From: Laura Gibbons <Laura.Gibbons@arun.gov.uk>
Sent: 08 June 2021 16:29
To: Planning.Responses <Planning.Responses@arun.gov.uk>
Cc: Simon Davis <Simon.Davis@arun.gov.uk>
Subject: RE: Planning Consultation on: Y/49/21/RES

We are unable to provide support to the reserved matters application at this time. The outline decision notice requires surface water drainage to be agreed at or before reserved matters. **We therefore raise a holding objection at this time.**

Application No: Y/49/21/RES
Registered: 19th April 2021
Site Address: Land East of Drove Lane Yapton BN18 0EB
Grid Reference: 497380 103194
Description of Works: Approval of reserved matters following Y/92/17/OUT for 300 No. dwellings covering landscape, layout, scale & external appearance (resubmission following Y/78/20/RES). This application affects the setting of listed buildings, affects the character & appearance of the Main Road/Church Road, Yapton Conservation Area & affects a Right of Way. This site falls within Strategic Site SD7 (Zero Rated).

POND 7

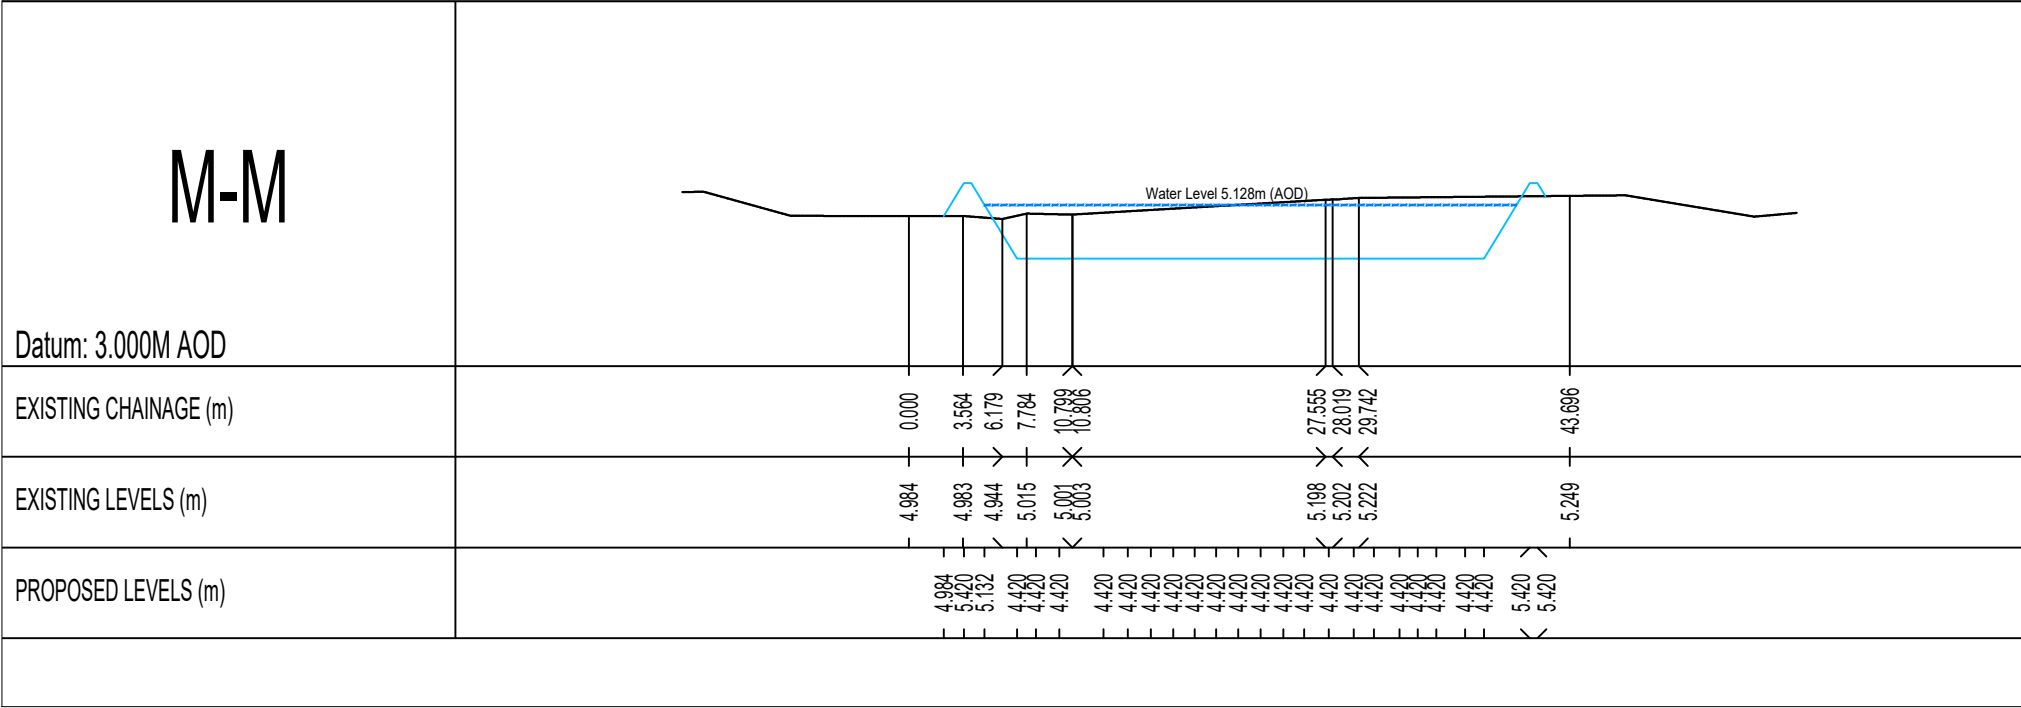
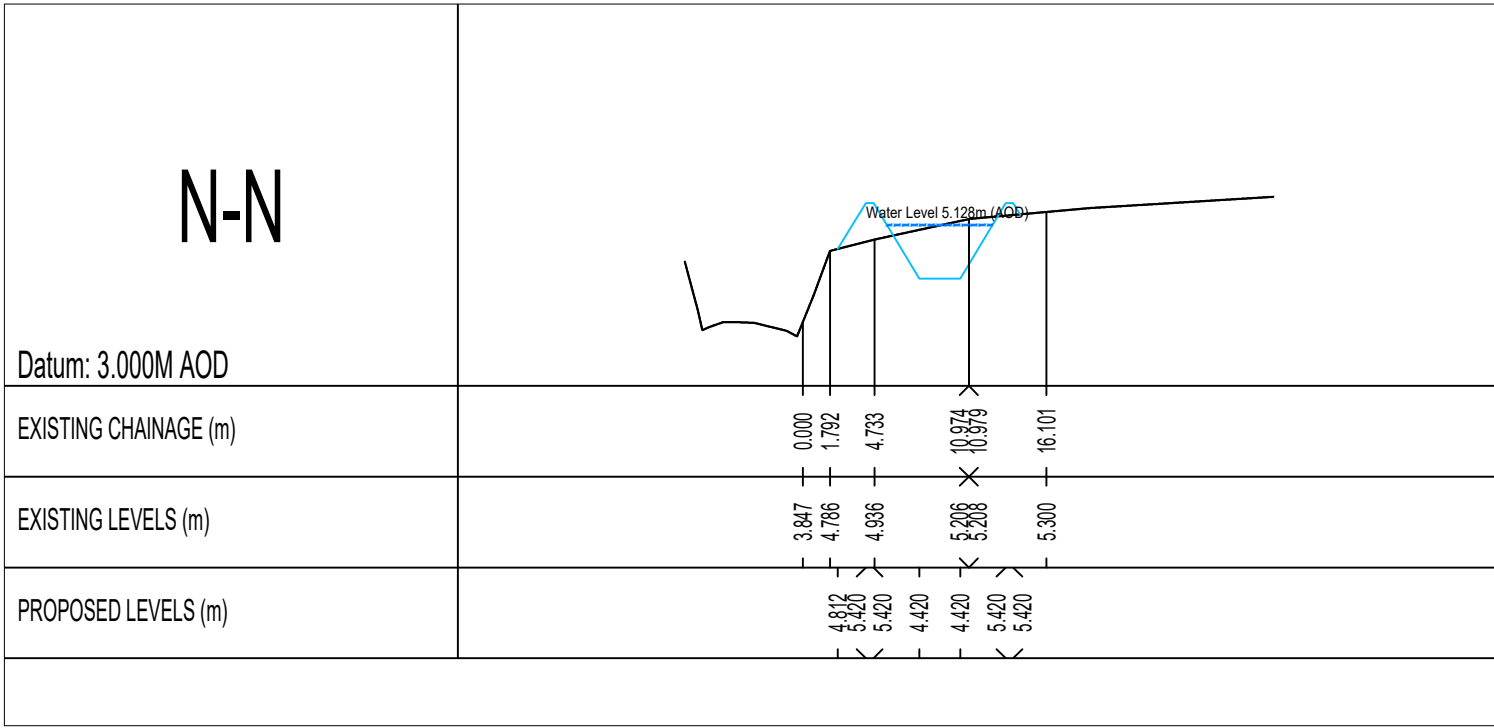
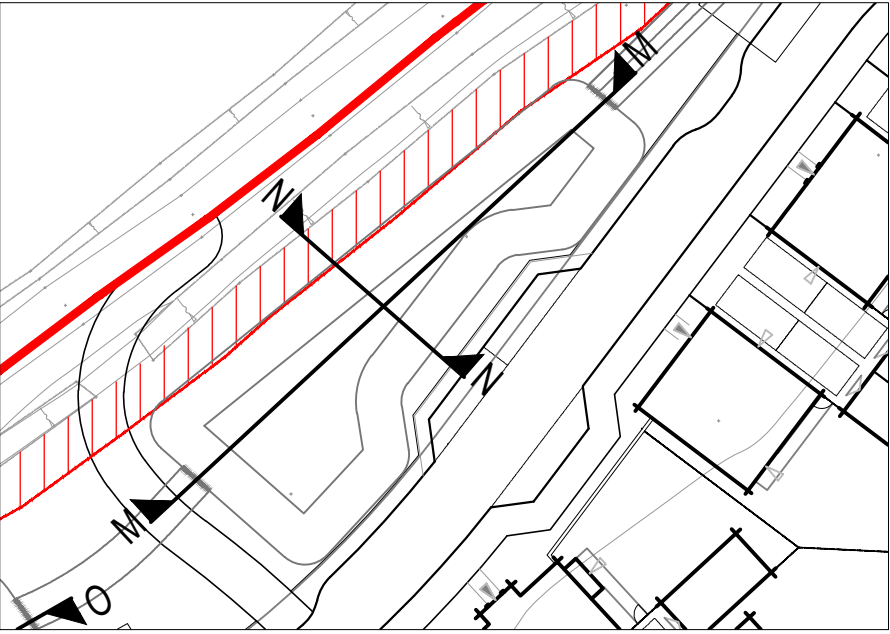
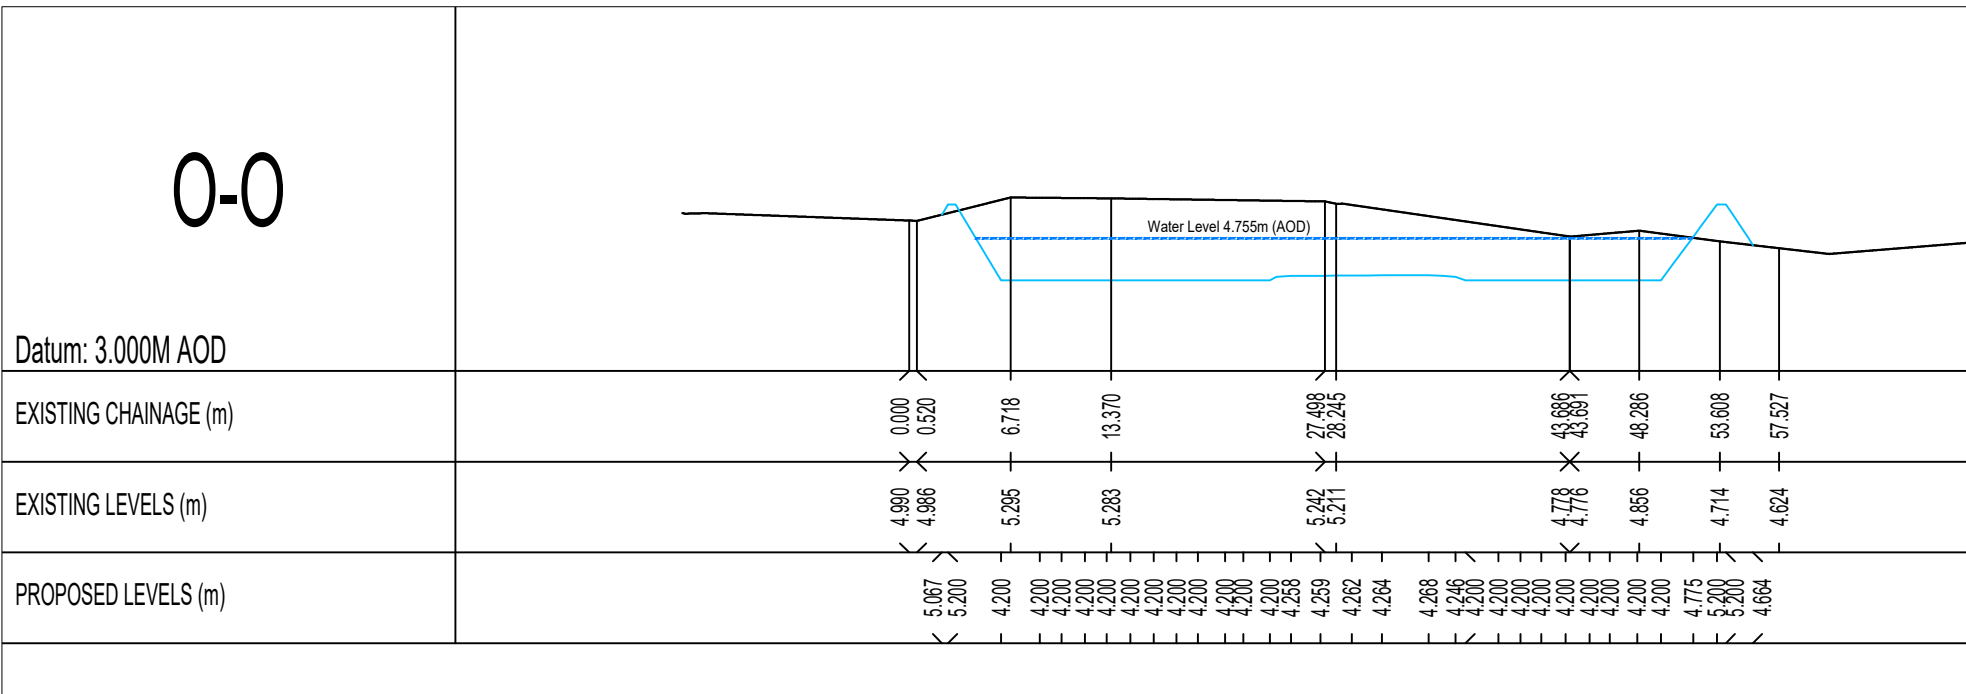
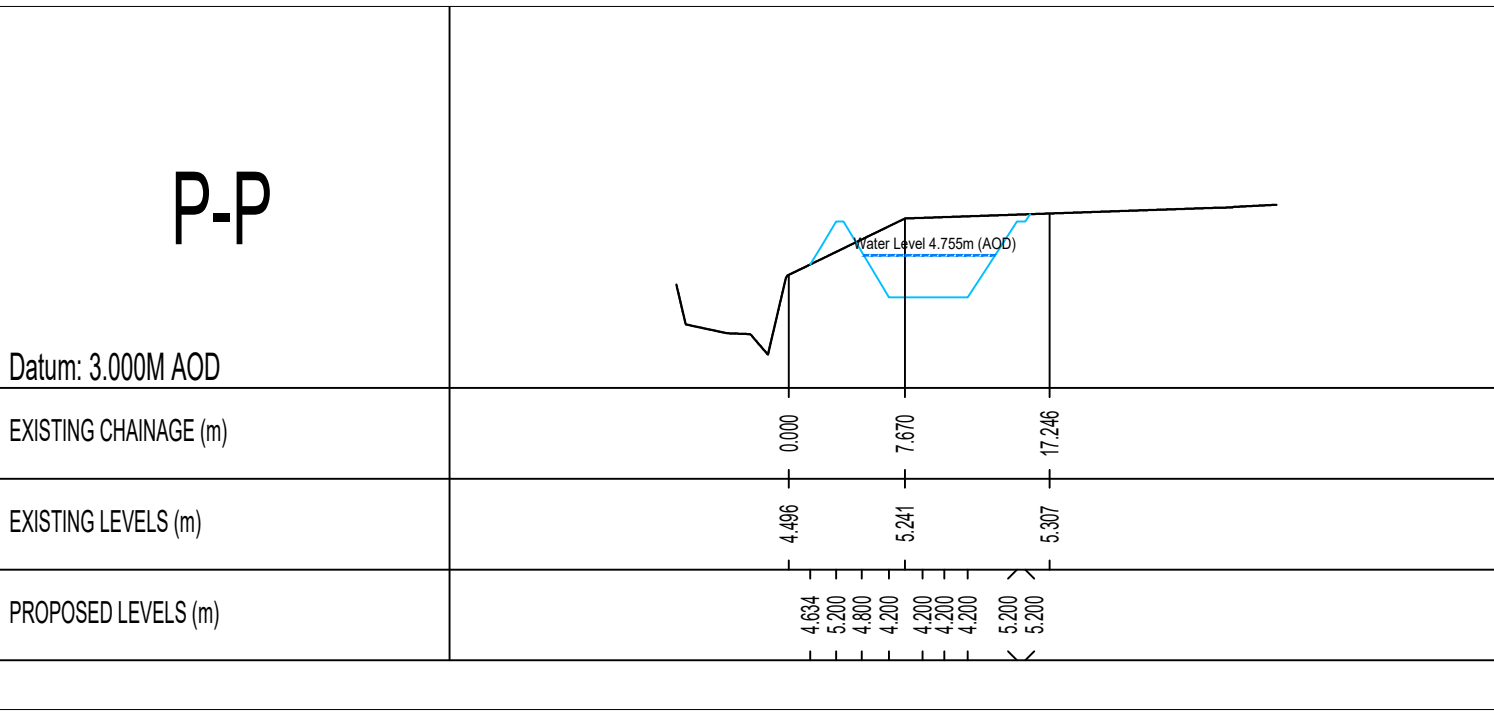
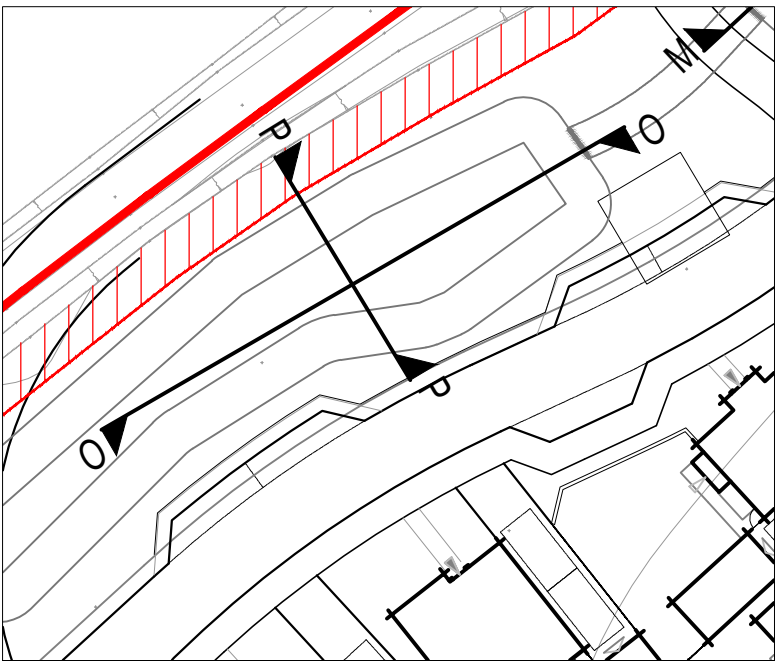
3. Please detail side slopes on cross sections of basins. — 1:3 gradient labels added to side slopes of cross sections. *okay, point closed.*
4. Pond 1, 2, 6, and 7 have insufficient freeboard, 300mm freeboard must be provided between maximum water levels and top of bank levels. Please review the design of ponds and swales to ensure that adequate freeboard is provided.

4. Pond 7 top of bank on section has been increased by 8mm to achieve 300mm freeboard. *Okay.*

2. Pond 7 is bunded on the western side only with the rest of the top of banks tying into the proposed levels. *Okay, ground raising proposals will need to be discussed with the planning officer.*

POND 8

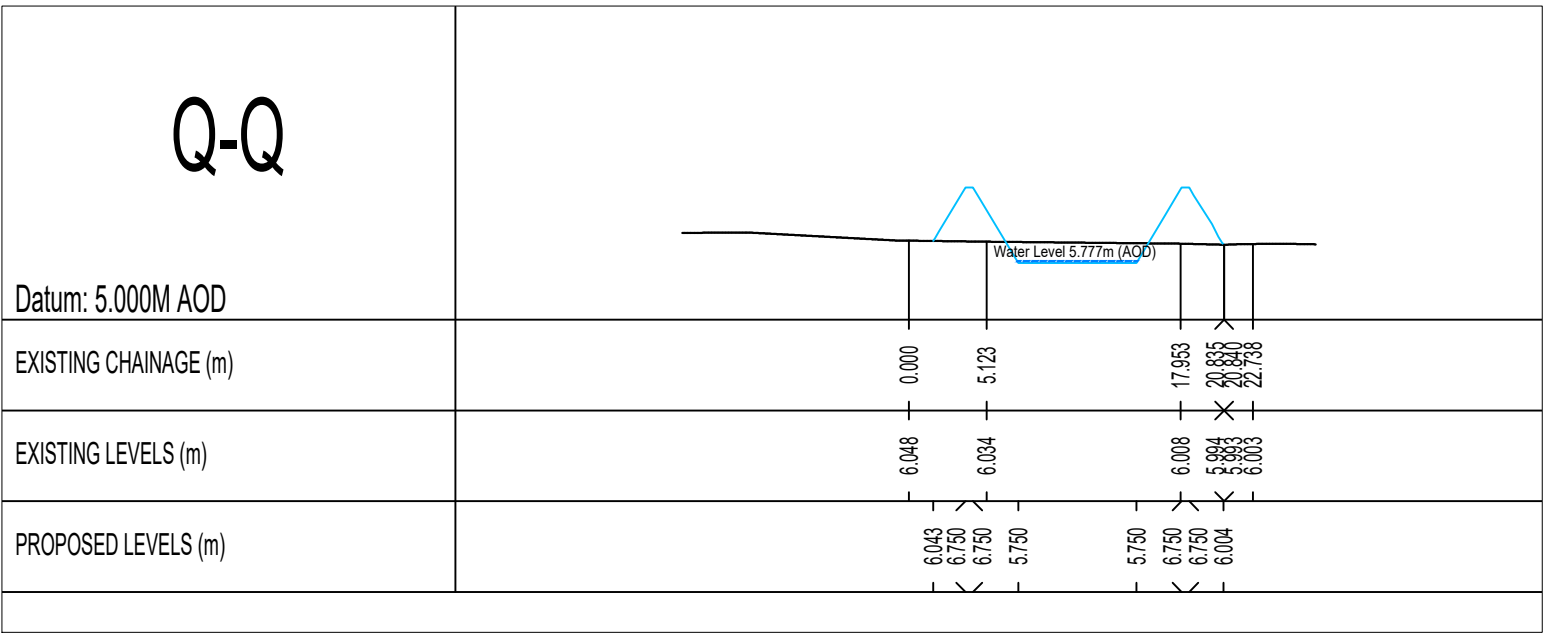
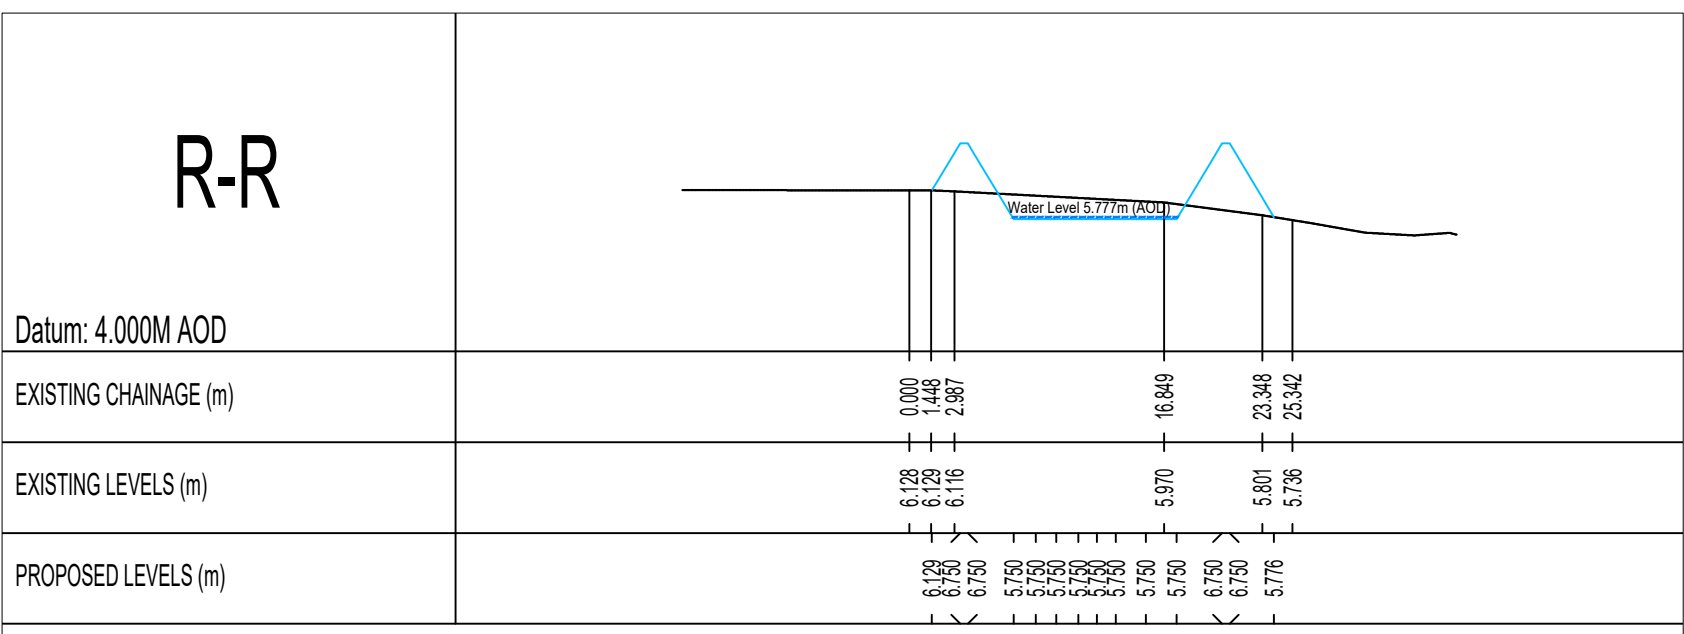
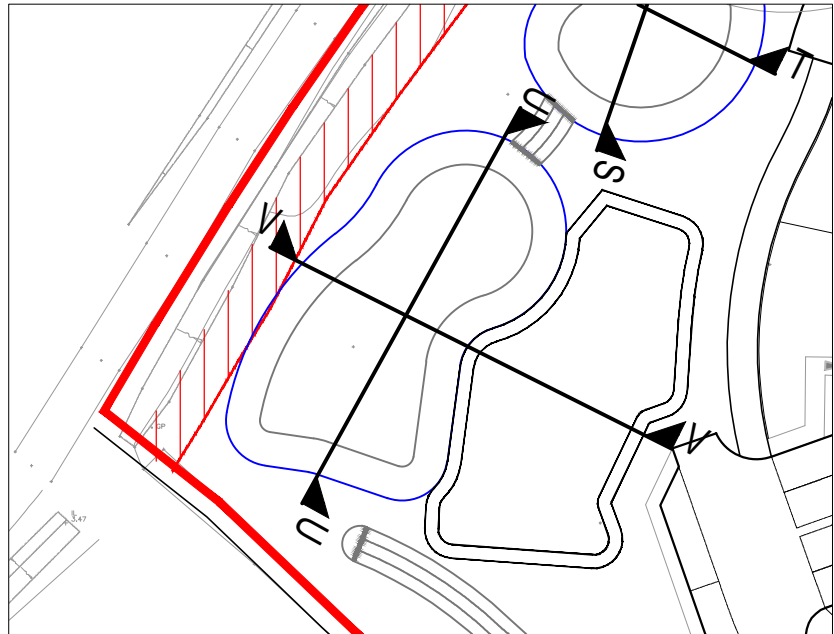
7. Likewise at pond 8 the water hardly gets into the pond base. Has consideration been given to providing crates with overlying stone, rather than a pond. There should be sufficient depth here to achieve this without needing to locally raise levels for cover. – There is cellular units below Pond 8 which form SA15 and they are fully utilised. The pond is a conveyance feature and ties into the proposed levels on the north, east and western sides with the southern side tying into the existing levels. Slope and width of crest added to section. *0.5m wide crest for a 0.75m high bund is not acceptable. Please review. Once again I would suggest that thought is given as to whether this pond is needed.*
